Your ref: EN020022

6 October 2020

Application by AQUIND Limited for an Order Granting Development Consent for the AQUIND Interconnector - Environment Agency's responses to ExQ1 (Deadline 1).

DRAWING NO:	REV:
AQD-WSP-OS-UK-DR-D-200140	01

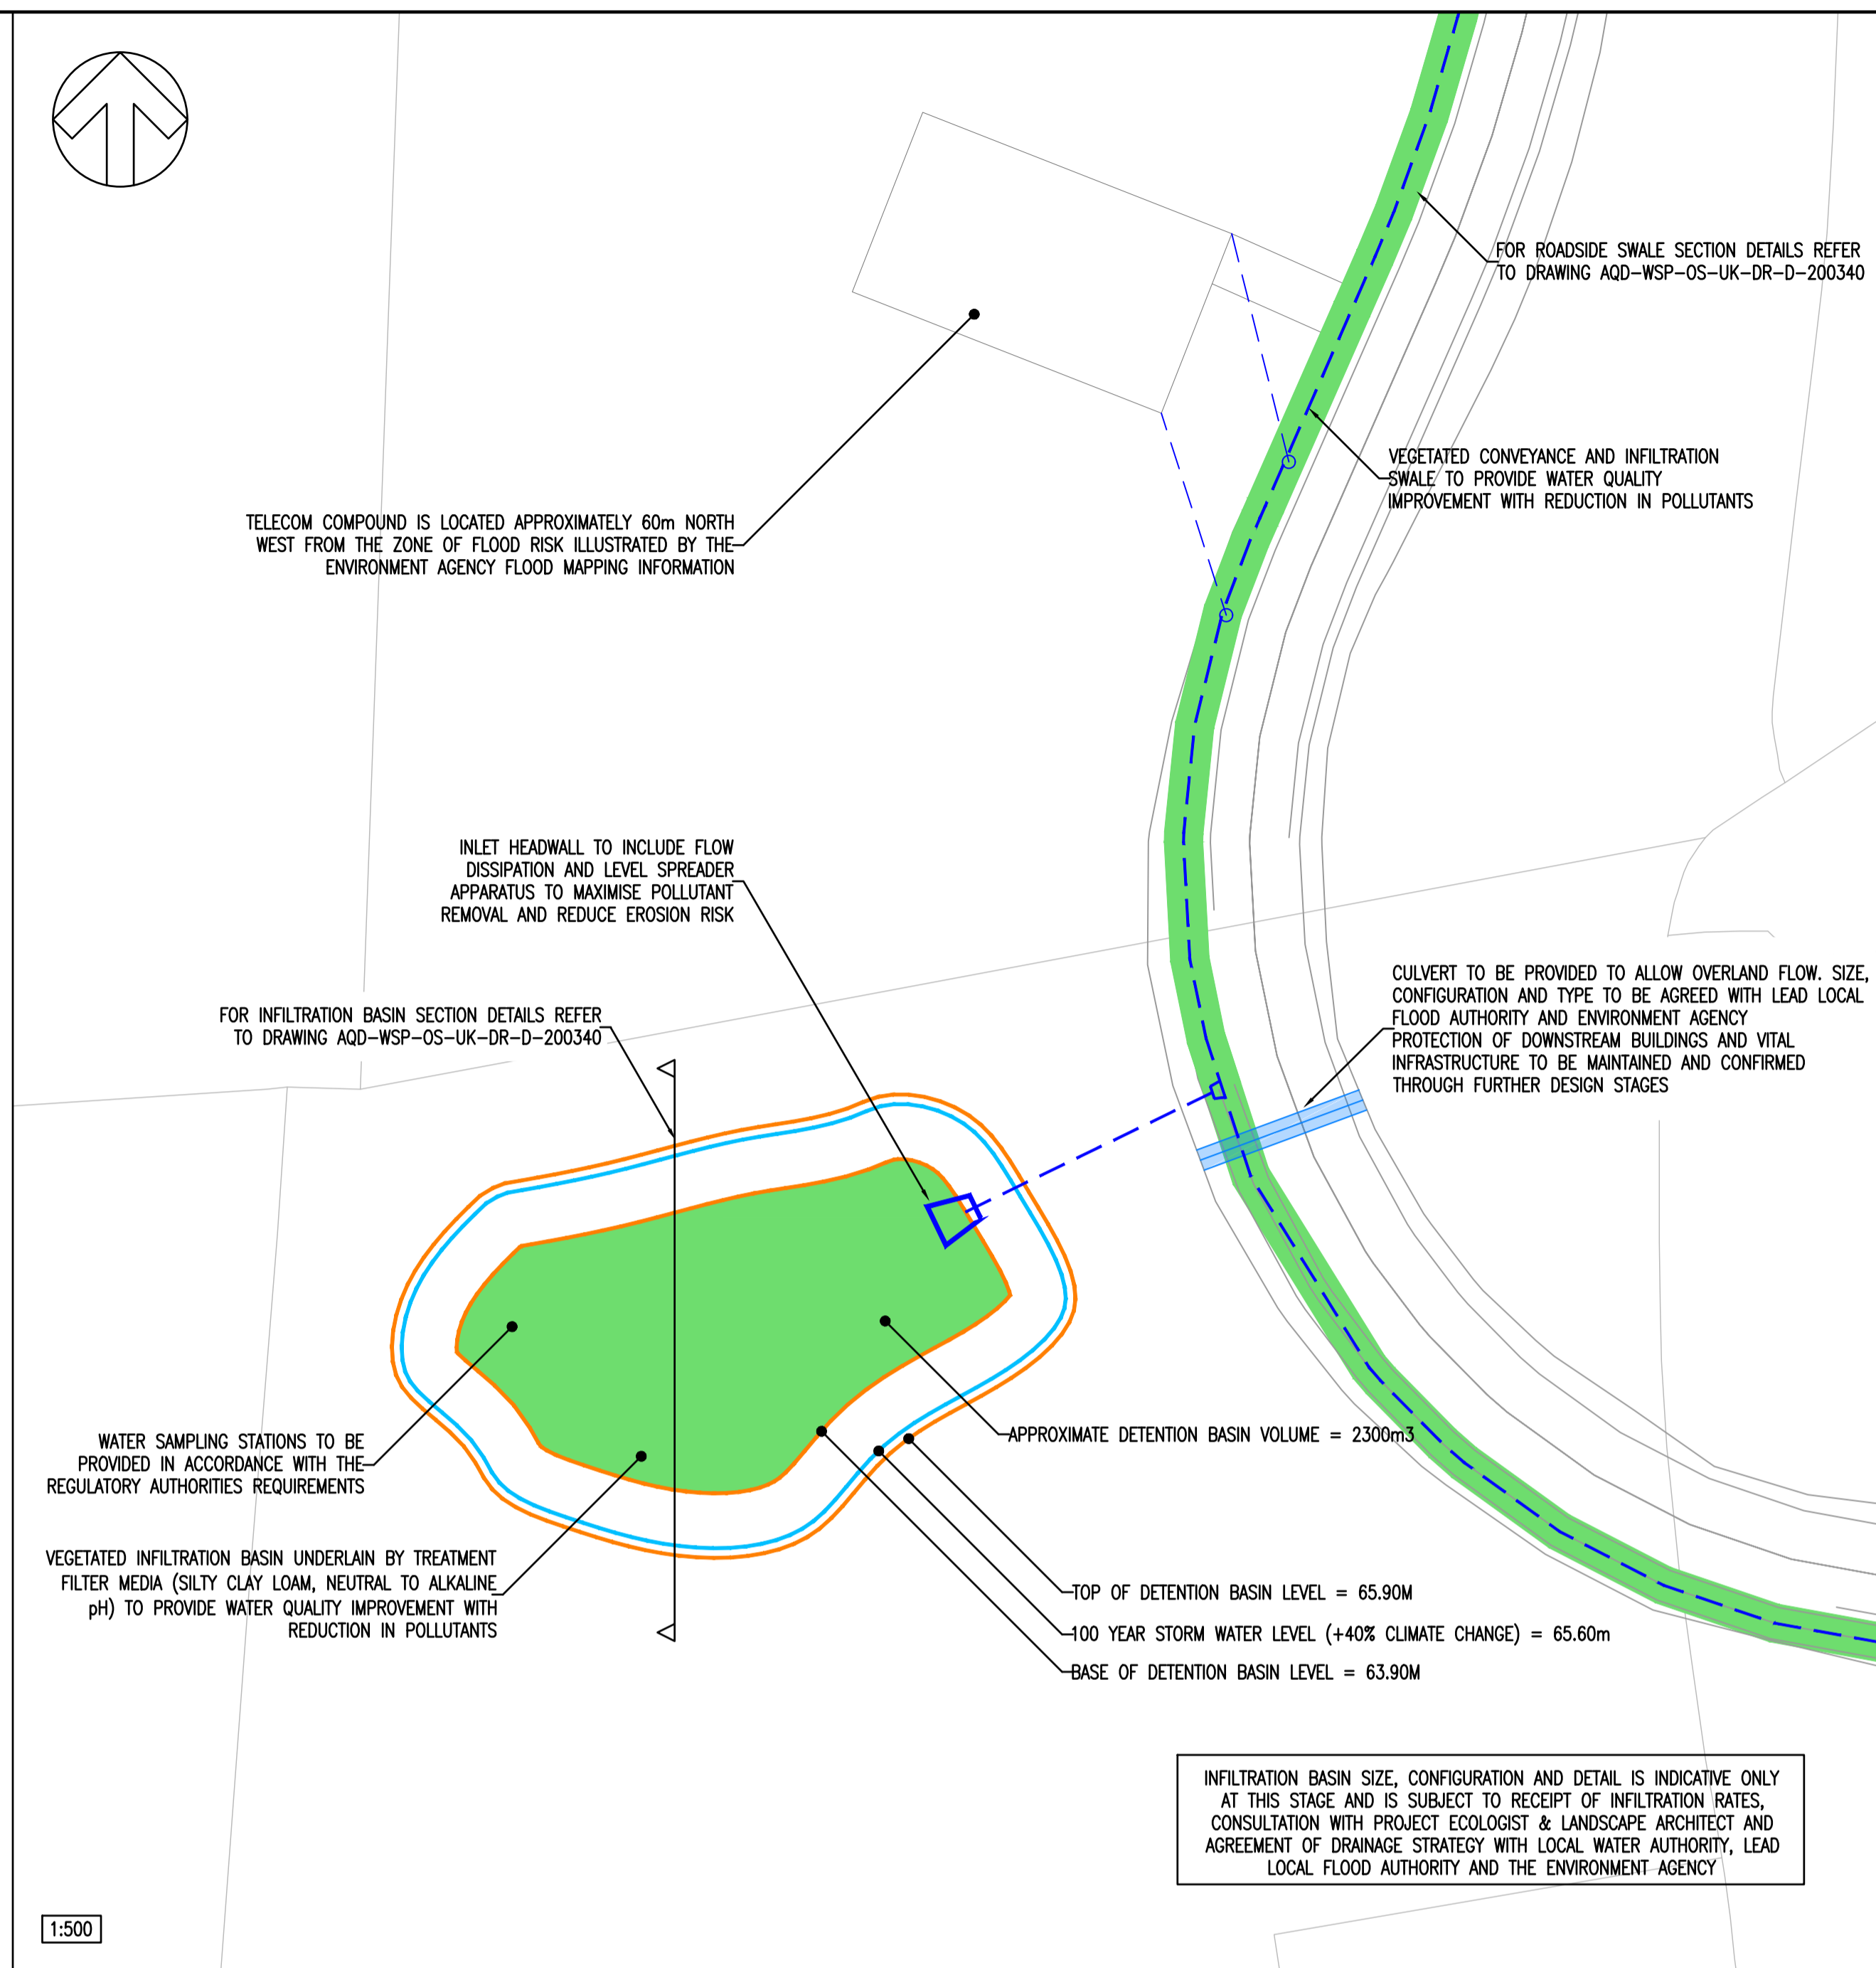
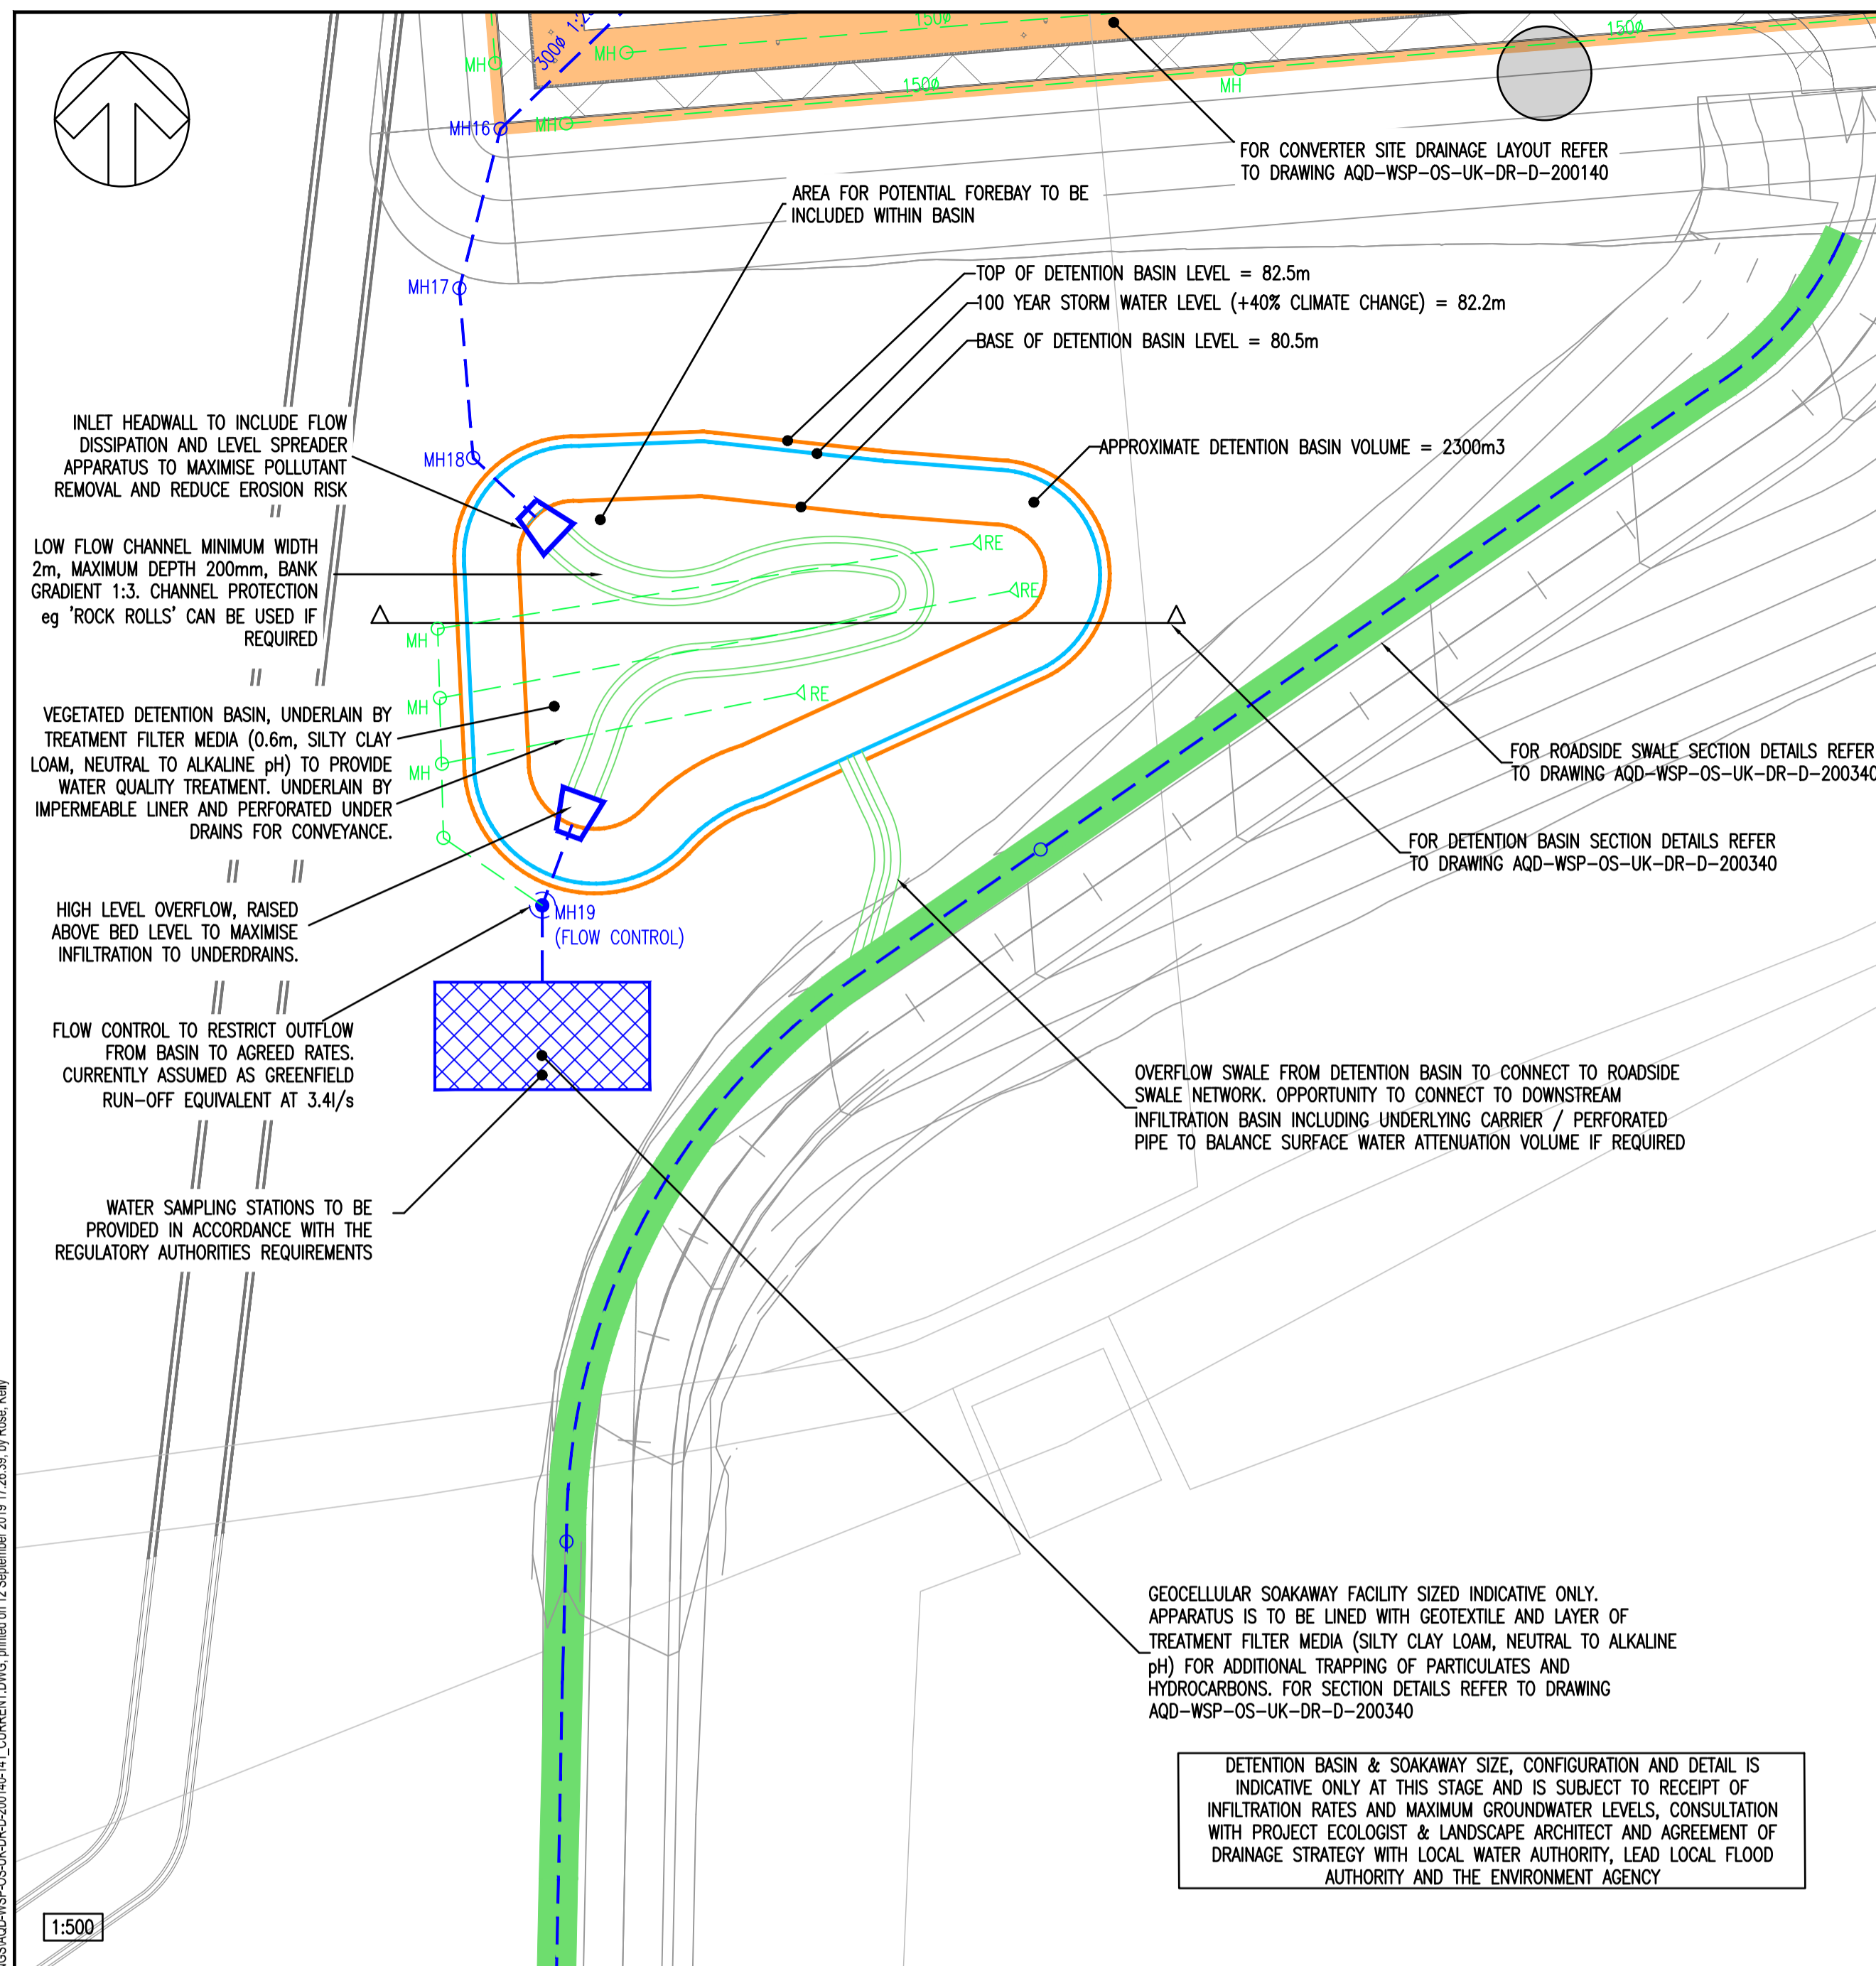
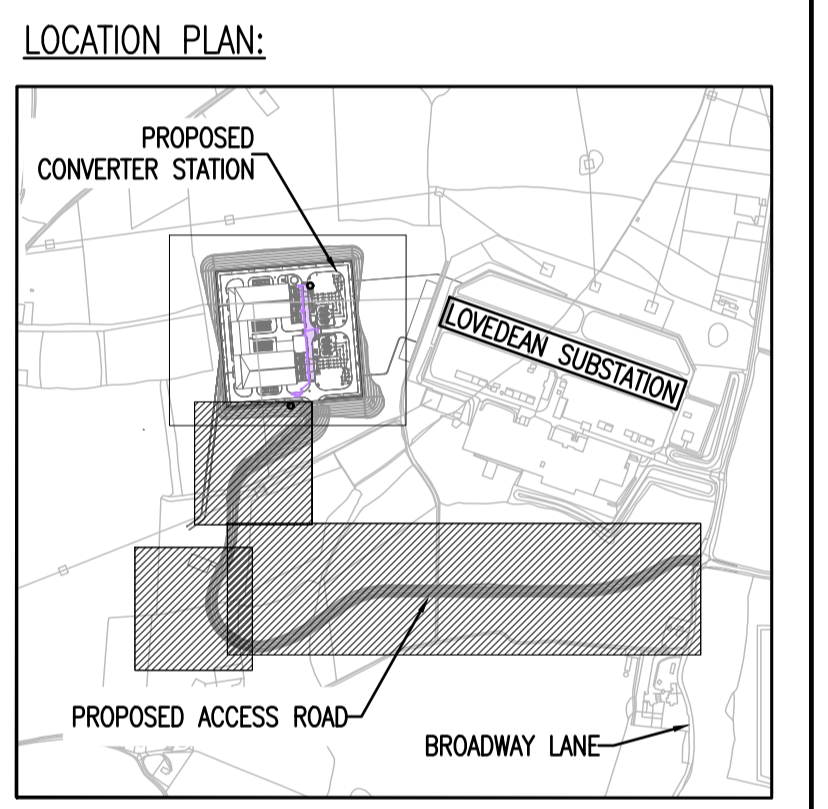
We are not content with the conclusion that there is no real risk to public water supply in Source Protection Zone 1 as a result of the proposals. We have raised this with the Applicant as part of our on-going discussions relating to the Converter Station site.

We do however agree that the risks can be managed if best practices and suitable controls are adopted, and detailed discussions have been held and will continue to be held with the Applicant about such practices and controls. Particular focus is upon the 'Surface Water and Aquifer Contamination Mitigation Strategy' (**APP-360**) which is a document that is intended to be updated by the Applicant in due course to reflect recent discussions held with us, Portsmouth Water and Hampshire County Council Lead Local Flood Authority.

We note that compliance with this document (**APP-360**) is referenced in the Requirements within the draft Development Consent Order (section 12(2) - **APP-019**), albeit this section is entitled “Surface and foul water drainage” which is not entirely reflective of the broader matters this document intends to cover. It may be helpful to amend the Requirement in due course, and we will work with the Applicant to address this if necessary as we proceed.

We (the Environment Agency, Portsmouth Water, Hampshire County Council Lead Local Flood Authority and the Applicant) are working towards the Surface Water Drainage and Aquifer Contamination Mitigation Strategy [**APP-360**] being a document that contains the fundamental principles and rules that will need to be applied to the proposal to afford the necessary protections of the underlying aquifers and public water supply. Therefore, any further development by the appointed contractor(s) at detailed design should not seek to lower the protections set out within that document and as far as we understand, this will be secured by the Applicant in any contractual arrangements with the appointed contractor(s). Further clarification from the Applicant may assist the ExA and Secretary of State in this regard.

Compulsory Aquisition Hearing 1 – Appendix 1
- Exhibit 15 Cross-section showing the typical
arrangement of the construction corridor
across Milton Common

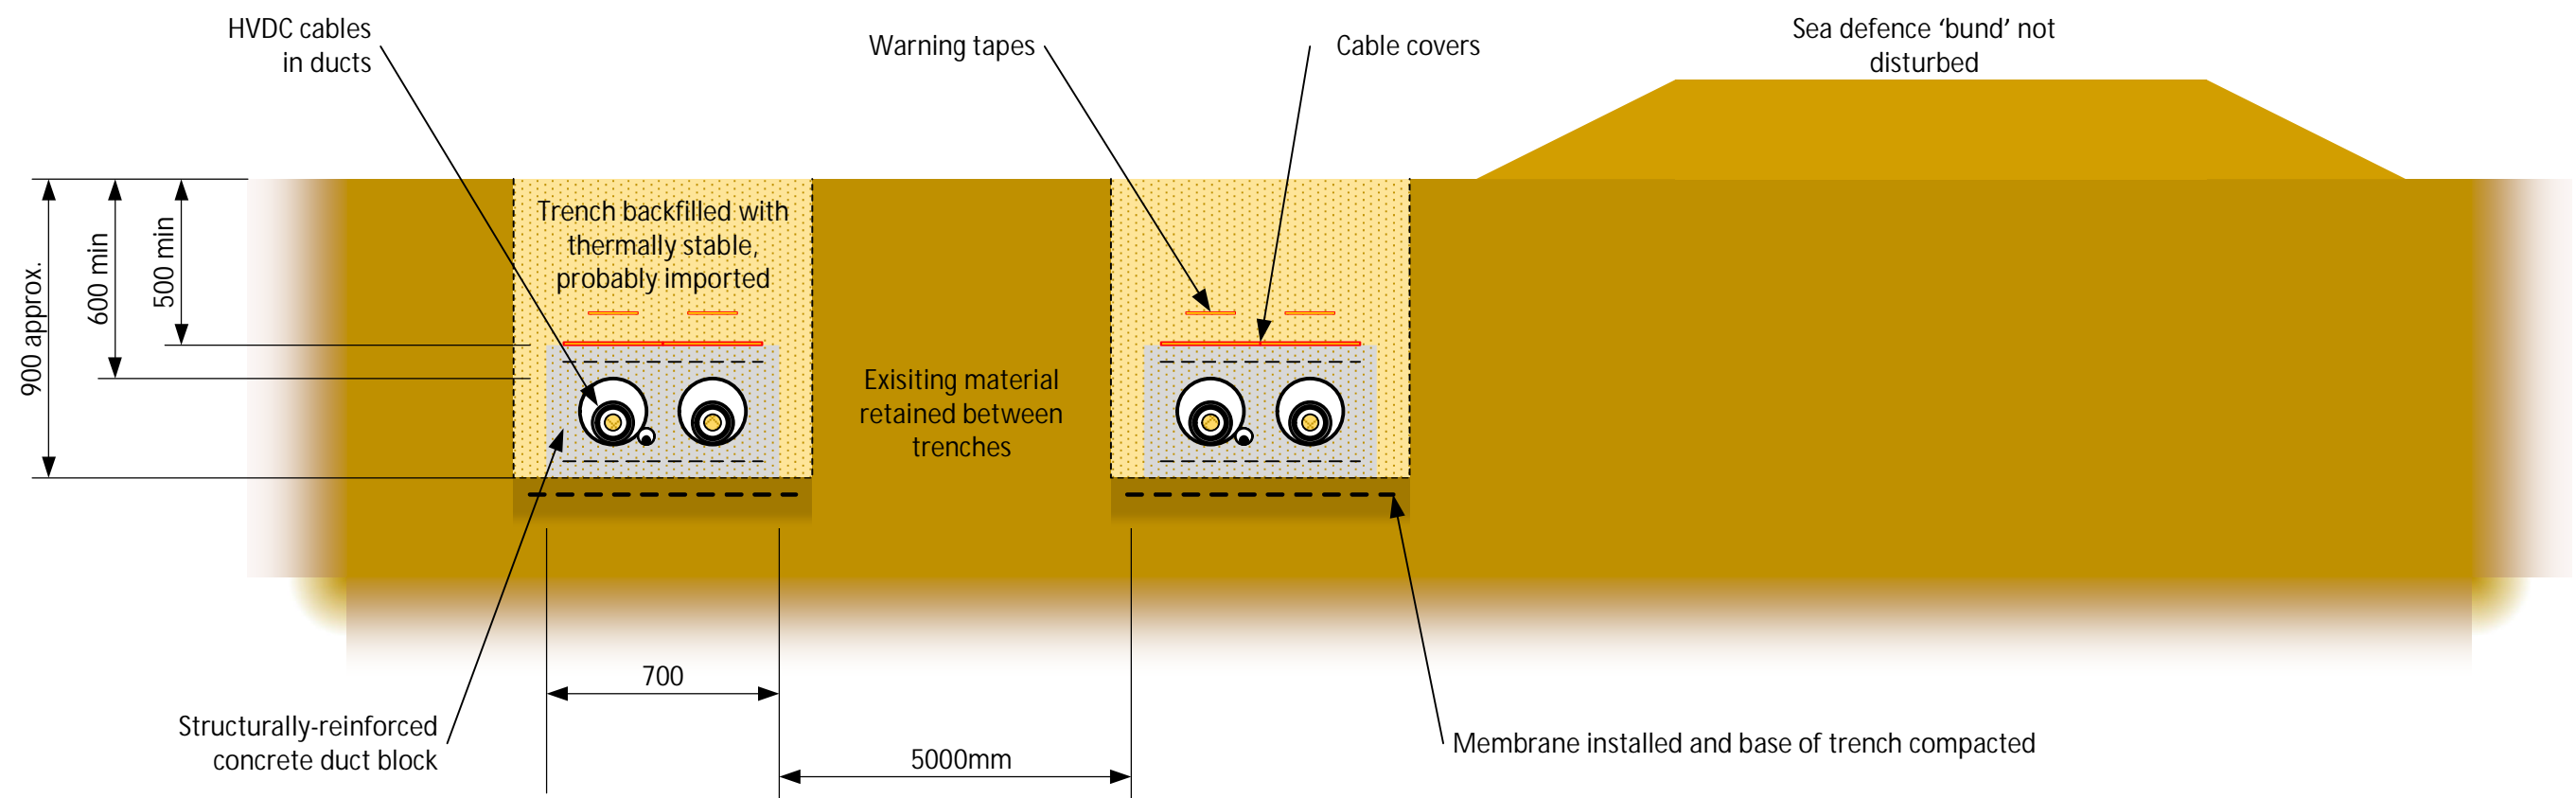
In regard to effects on the water environment/groundwater, we agree with the Applicant that the risk is low on the vast majority of the cable route save for certain localised areas such as Milton Common. Information regarding how contamination will

be dealt with is high-level at present (with reference to section 18.9 of the Environmental Statement Chapter 18 Ground Conditions (**APP-133**) and the Onshore Outline CEMP (**APP-505**)). However, we are content with the overarching principles specified and that more detailed CEMPs for each relevant part of the Proposed Development will be produced by the appointed contractor(s) and provided to relevant authorities for review, including the Environment Agency where necessary (due to the presence of sensitive groundwater features present in that particular part of the Proposed Development).
